**KIRKLEES METROPOLITAN COUNCIL  
INVESTMENT & REGENERATION SERVICE**

**DELEGATED DECISION TO DETERMINE PLANNING APPLICATIONS**

Reference No:	<b>2025/62/92638/E</b>
Site Address:	6, Ashbourne View, Cleckheaton, BD19 5JE
Description:	Erection of side and rear extensions with hardstanding to front elevation
Recommending Officer:	Jennifer Booth

**DECISION - Refused**

Drawing Title
 PROPOSED

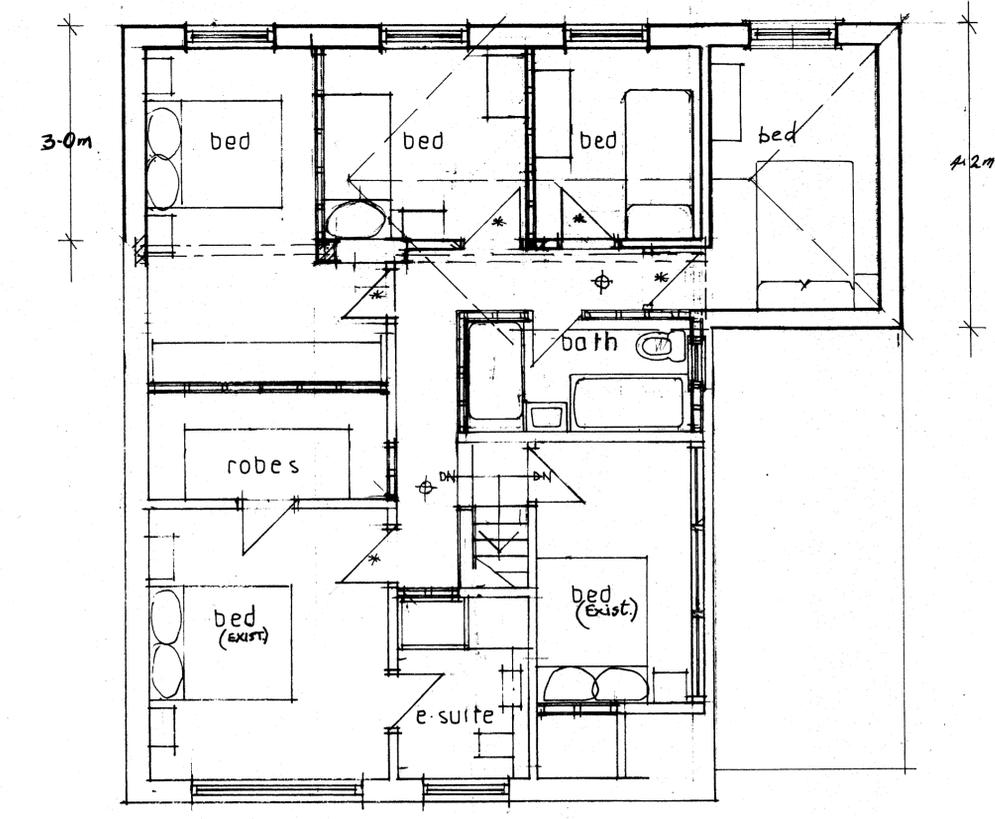
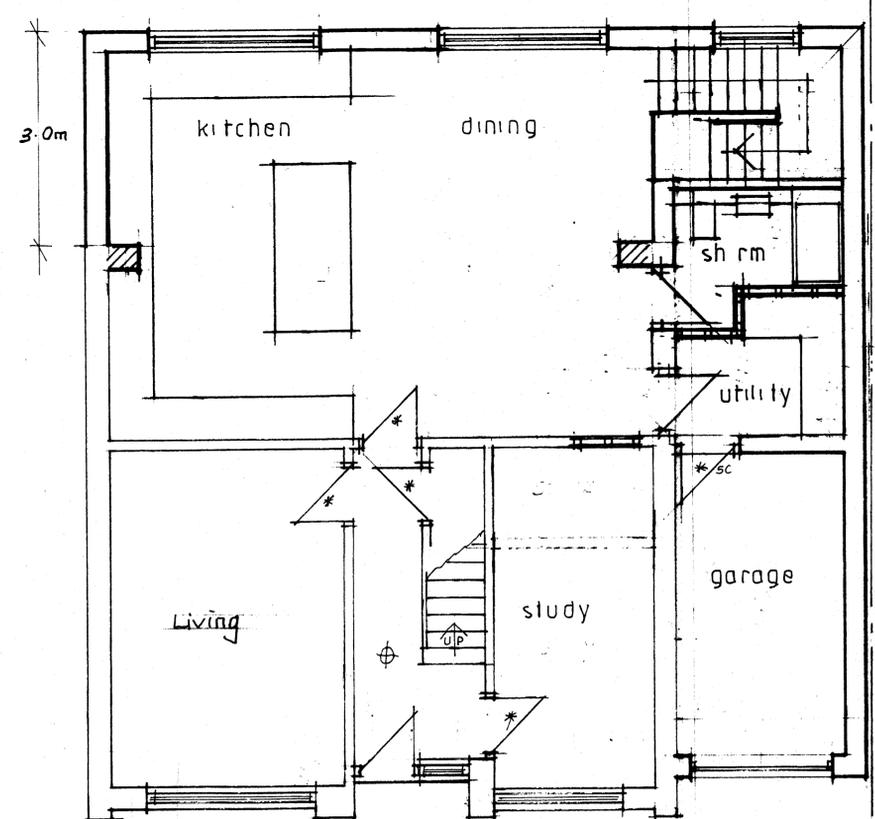
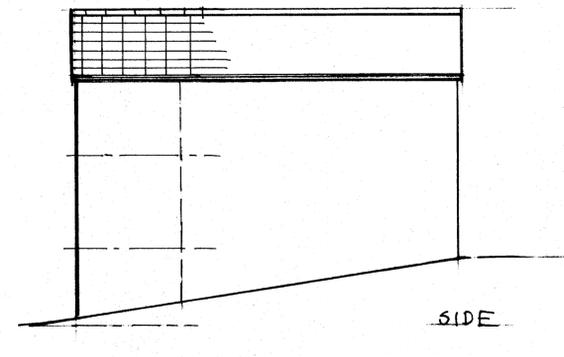
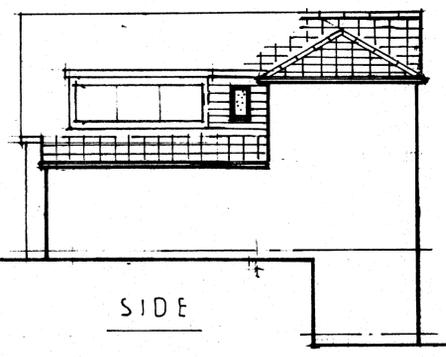
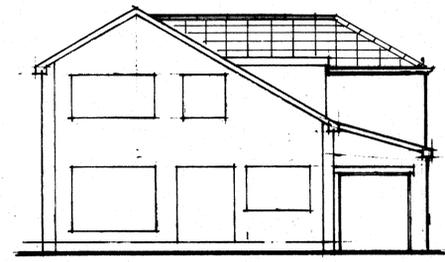
The proposed side and rear extension would result in a form that appears irregular when viewed from the front and side, particularly in combination with the existing car port and side dormer, creating an incongruous relationship with the established street scene. While the rear element is larger in width than the comparable extension at the adjacent property (No. 8), the proposed materials would match those of the host dwelling. However, despite this, the overall design and scale are considered to be visually harmful and therefore unacceptable.

The neighbouring property at No. 4 lies to the east of the application site. While any overshadowing would be limited to the late afternoon, the proposed extension, particularly the side element, would be positioned close to the shared boundary. This proximity, combined with the overall scale and bulk of the extension, would create an overbearing and oppressive impact on the neighbouring windows, adversely affecting outlook. Additionally, the works would introduce windows closer to the boundary with No. 4; however, these openings would primarily provide angled views towards the lower part of the neighbour's garden, reducing direct overlooking. Despite this, the overall relationship is considered harmful to the residential amenity of No. 4.

The proposed side extension, when viewed from the front and side, would appear irregular in form due to its relationship with the existing car port and side dormer, resulting in a discordant and incongruous appearance that is at odds with the established character of the street scene. The scale and layout of the development fail to respect the form and design of the host dwelling and surrounding properties, contrary to Policy LP24(a) and (c) of the Kirklees Local Plan, Key Design Principles 1 and 2 of the House Extensions & Alterations SPD, and Chapter 12 of the National Planning Policy Framework, which seek to ensure development is visually attractive and sympathetic to local character.

The proposed extension, by virtue of its scale, siting and proximity to the shared boundary with No. 4, would result in an overbearing and oppressive impact on the neighbouring property, significantly harming the outlook from its windows. This would fail to safeguard the residential amenity of the adjacent occupiers, contrary to Policy LP24(b) of the Kirklees Local Plan, Key Design Principles of the House Extensions & Alterations SPD, and paragraph 130 of the National Planning Policy Framework, which seek to ensure development provides a high standard of amenity for existing and future users.

The plans raise concerns in terms of the irregular appearance from the front and the overbearing and oppressive impact of the side/rear extension on the adjacent 4 Ashbourne View. Amended plans have not been sought.
